25 October 2018

**Re: Bowral Hospital SSDA Queries**

Kind regards,  
Site Image (NSW) Pty Ltd

Main Entry and Carpark

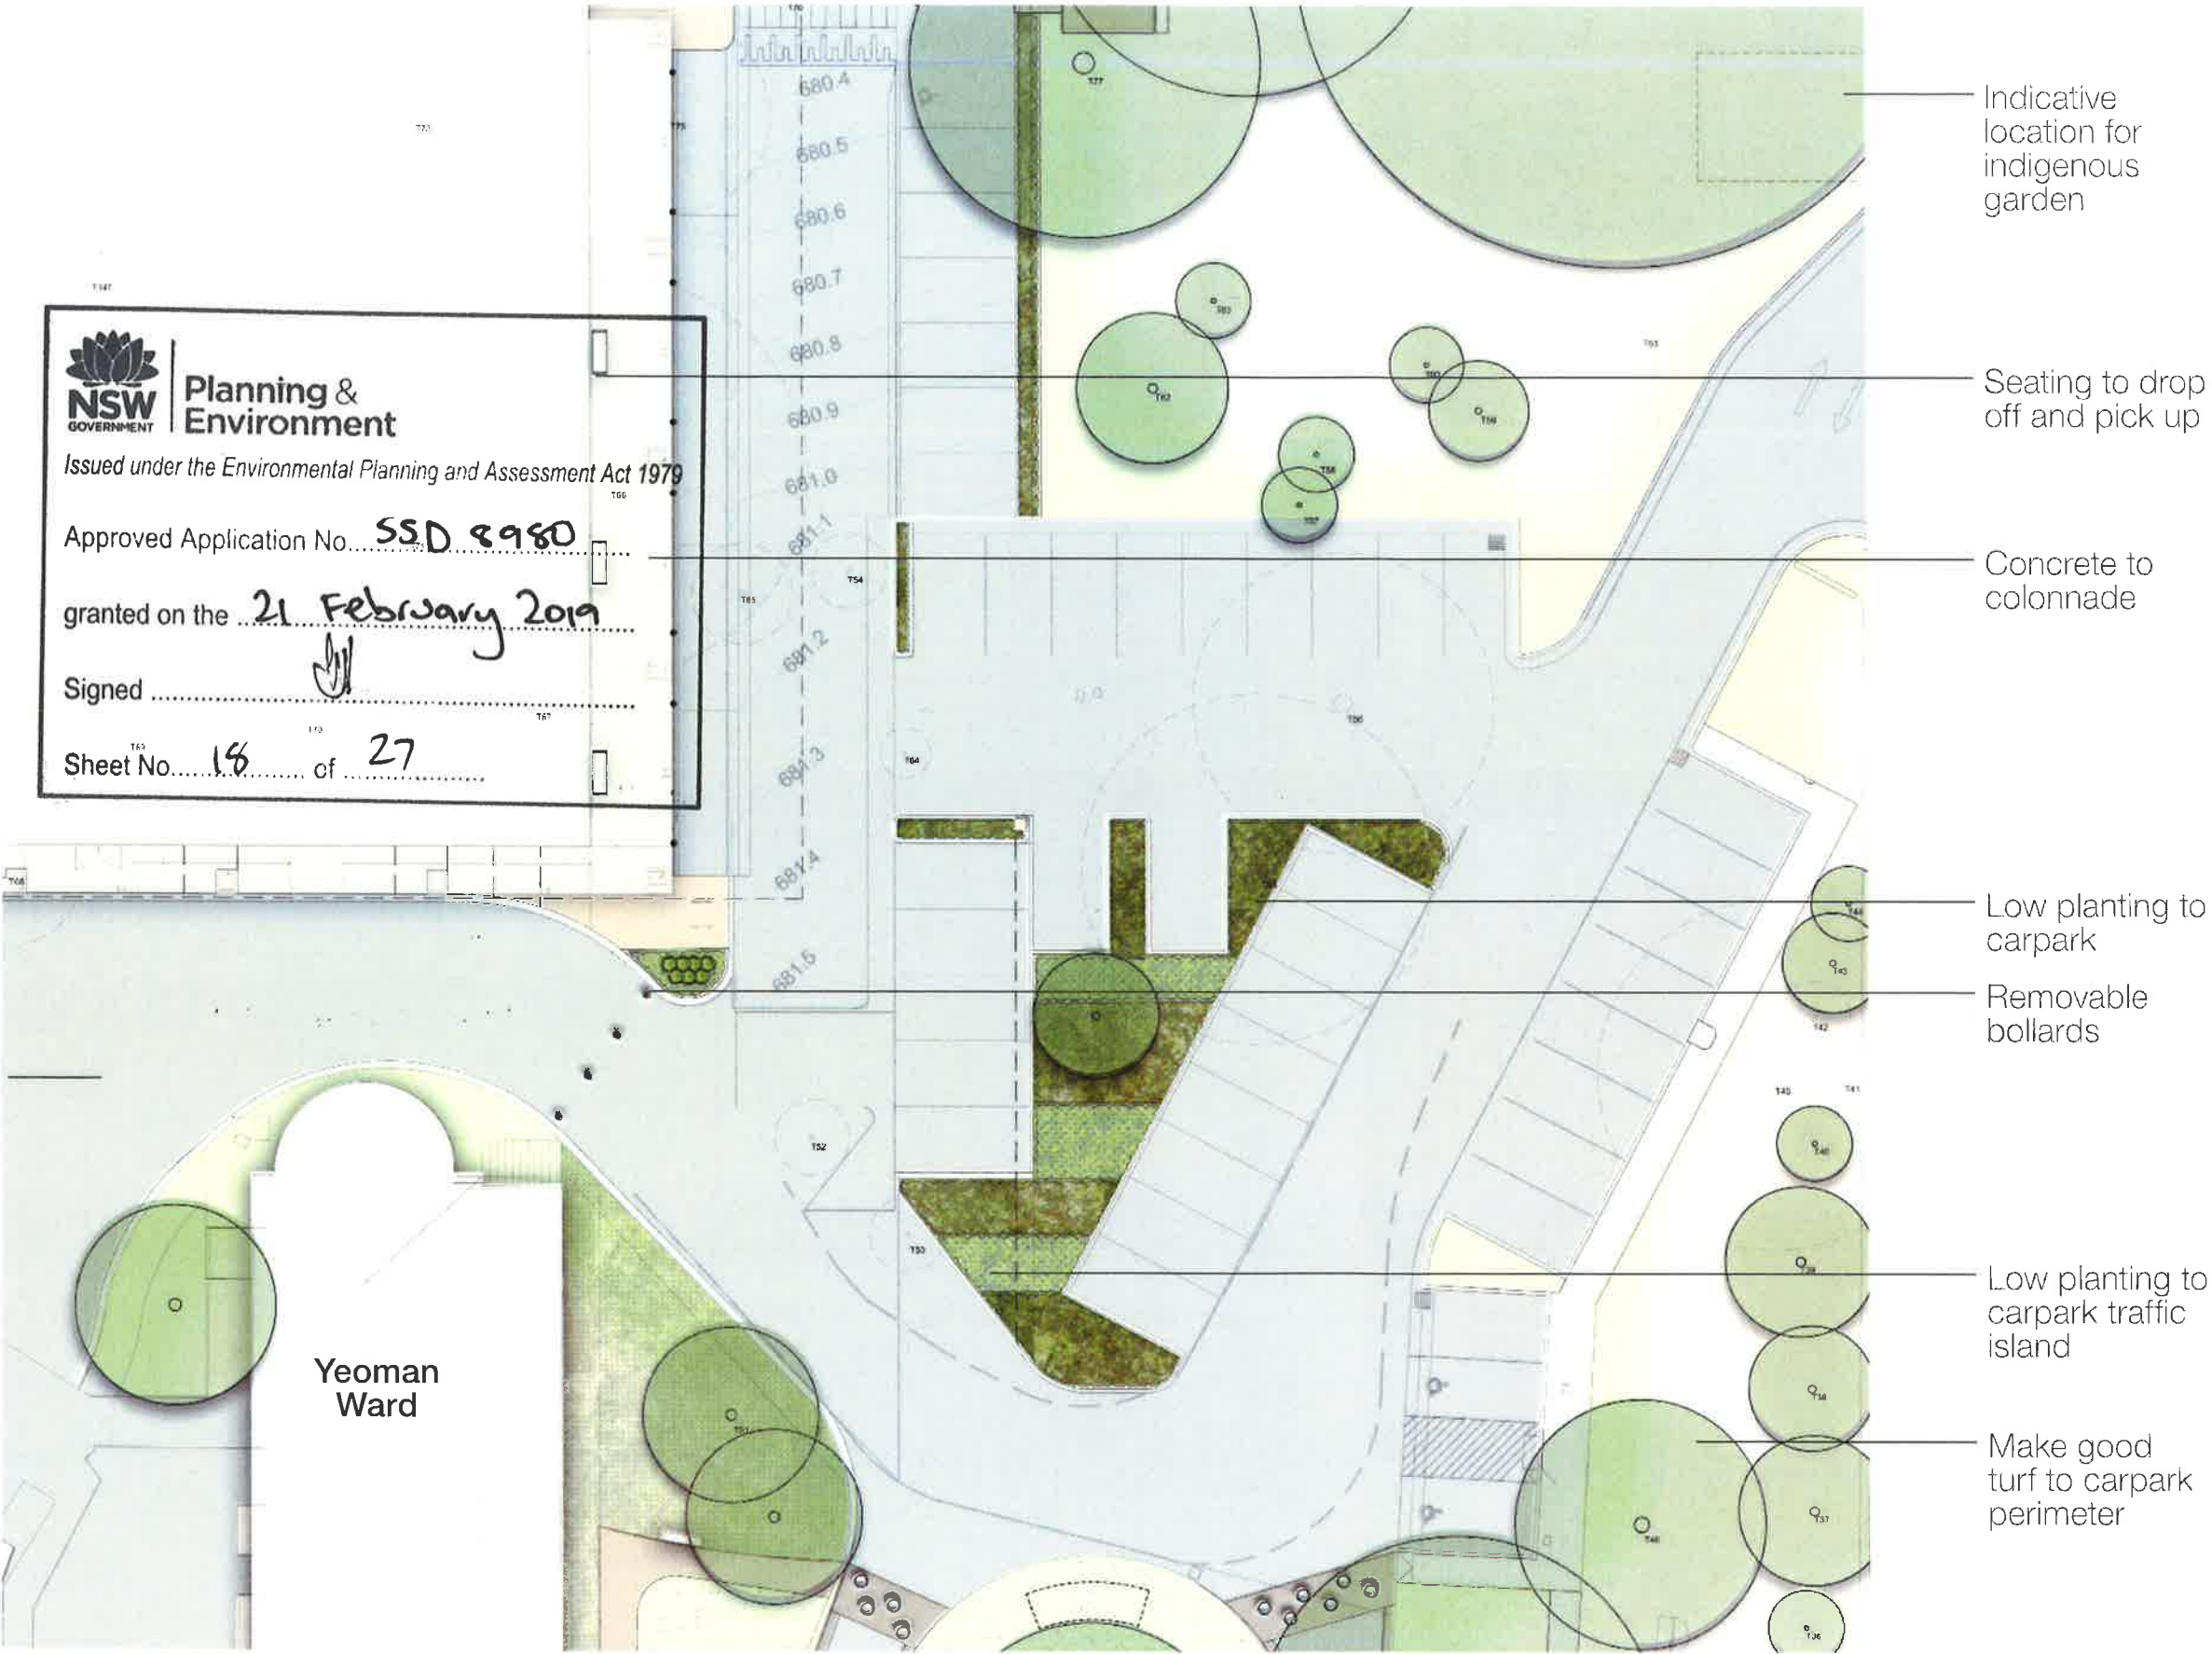
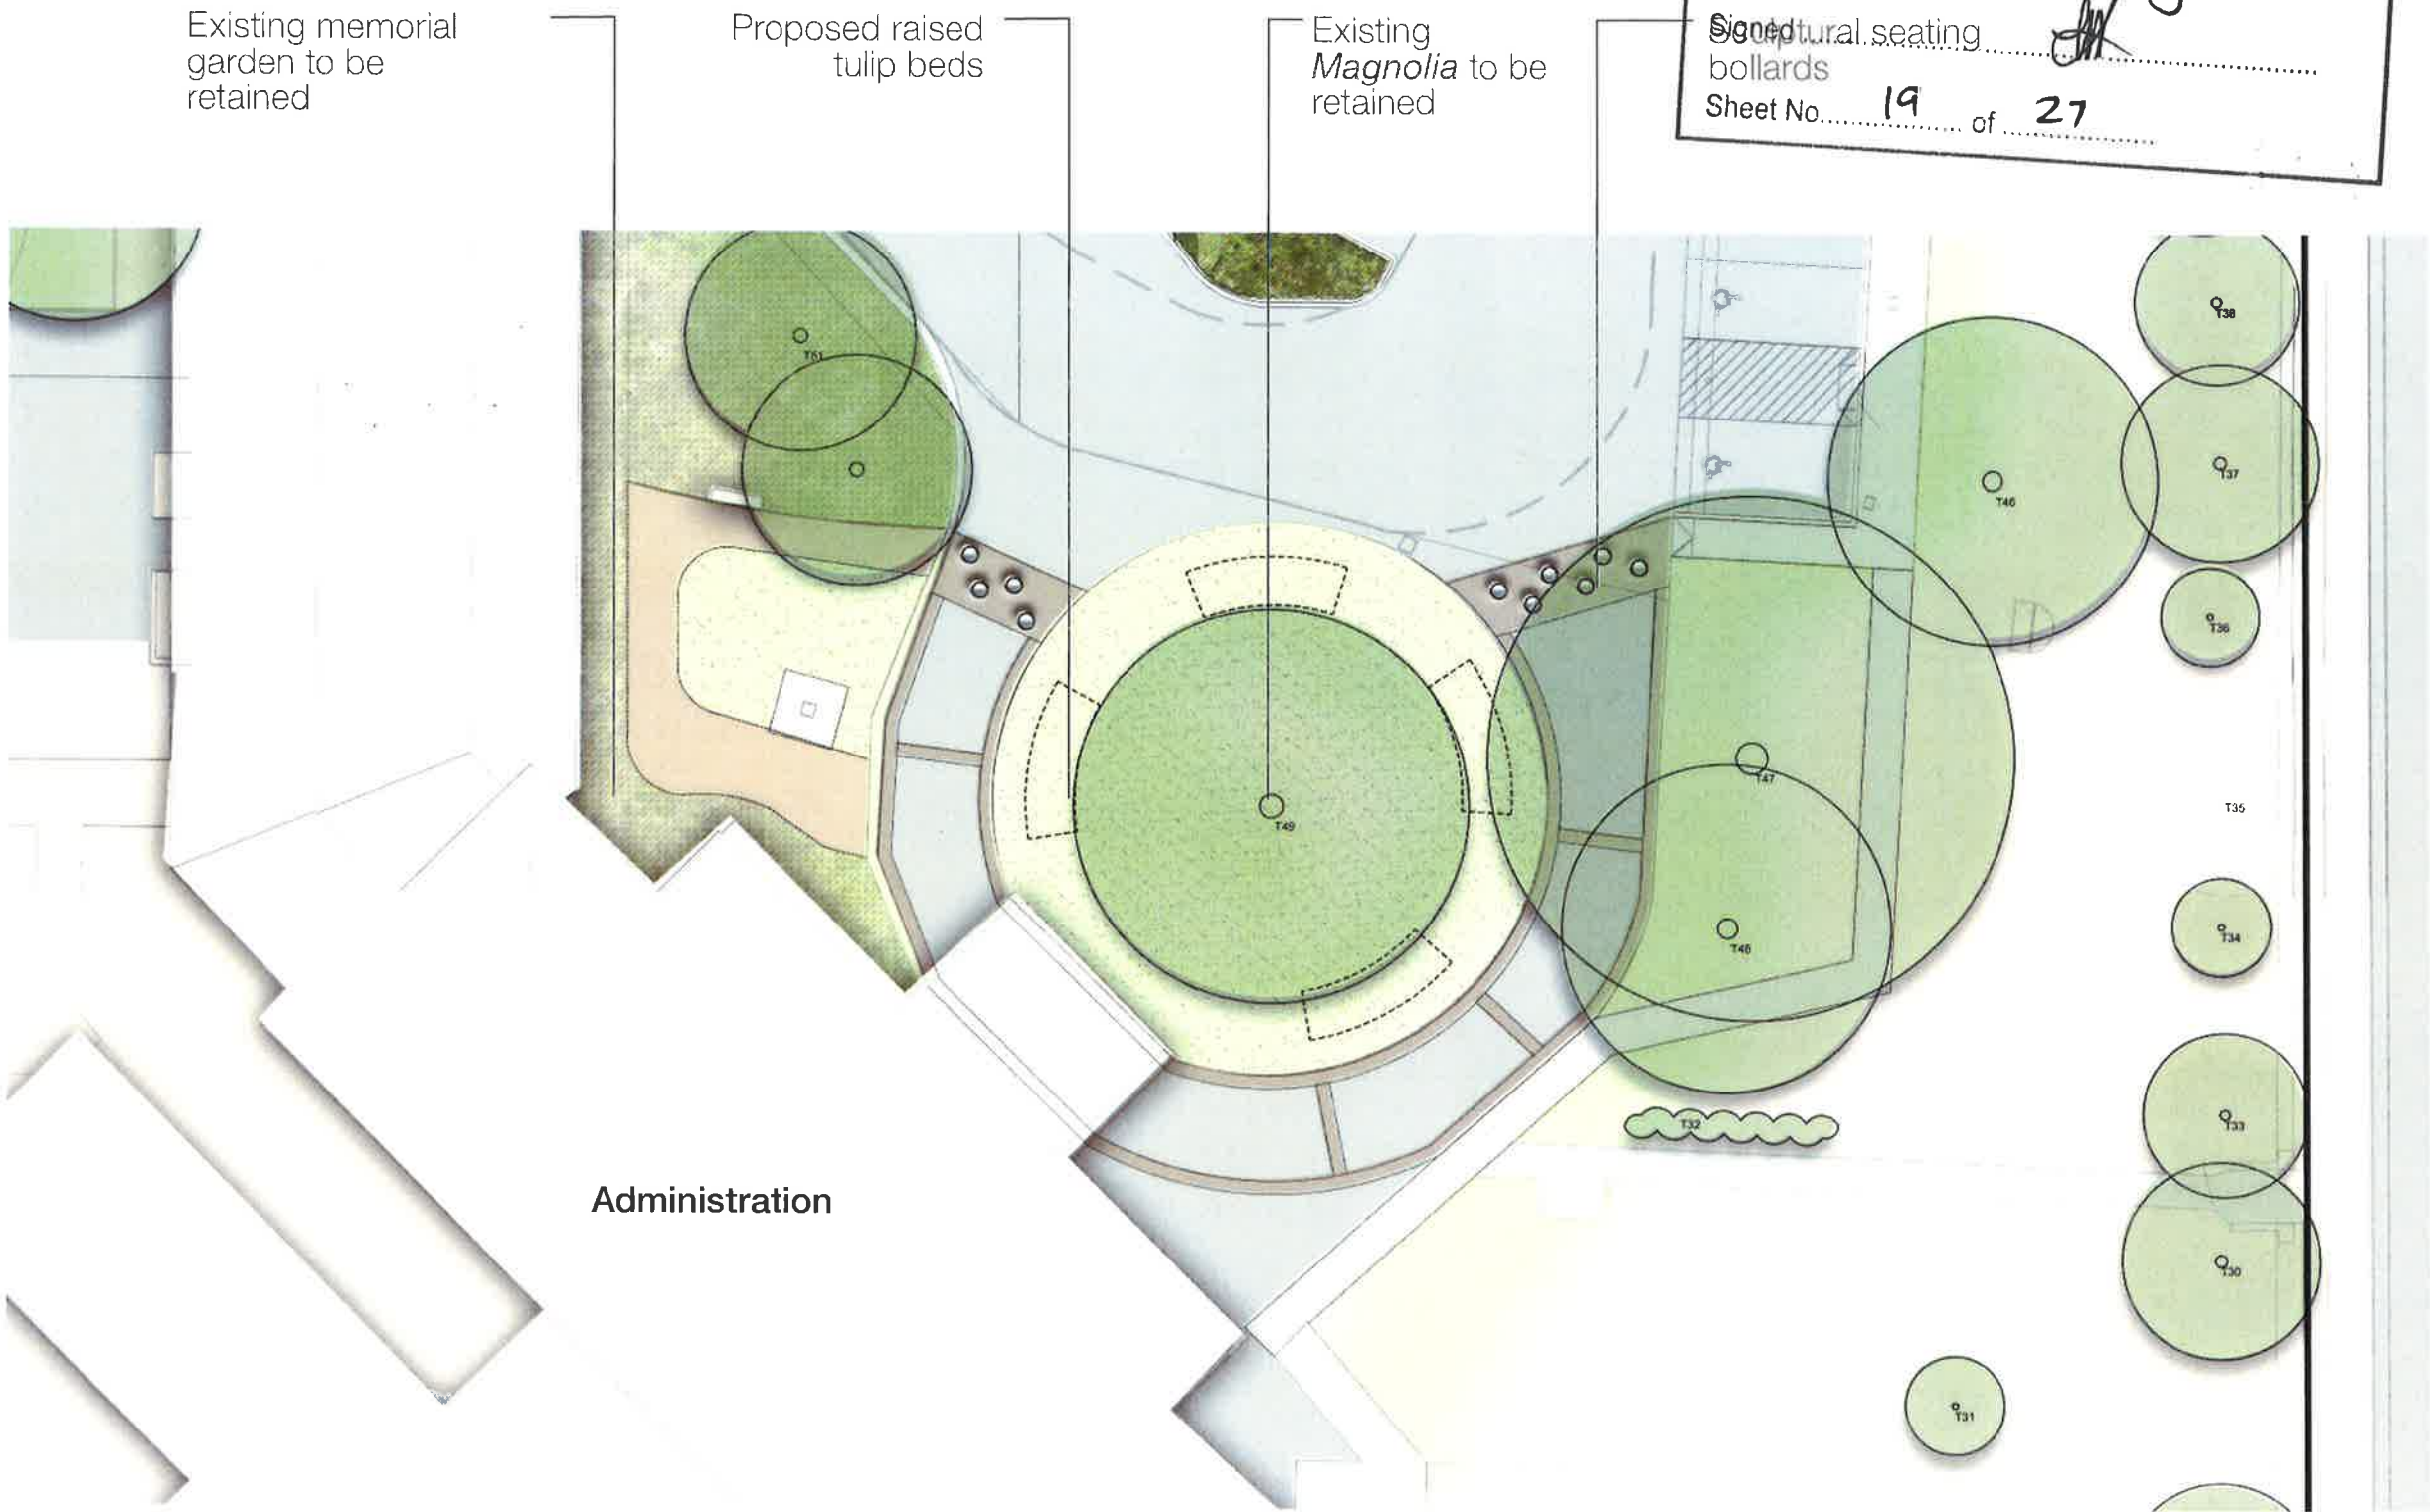
- *The 'main entry and carpark' landscape plan (drawing no.005, issue C) includes several trees along Mona Road frontage Identified as tree no/s T40-T45, however there is no mention of these trees in the submitted arborist report*

Trees 40-45 were included in an earlier revision of the arborist report, it is possible that they have been removed in the interim and therefore deleted from submitted arborist report.
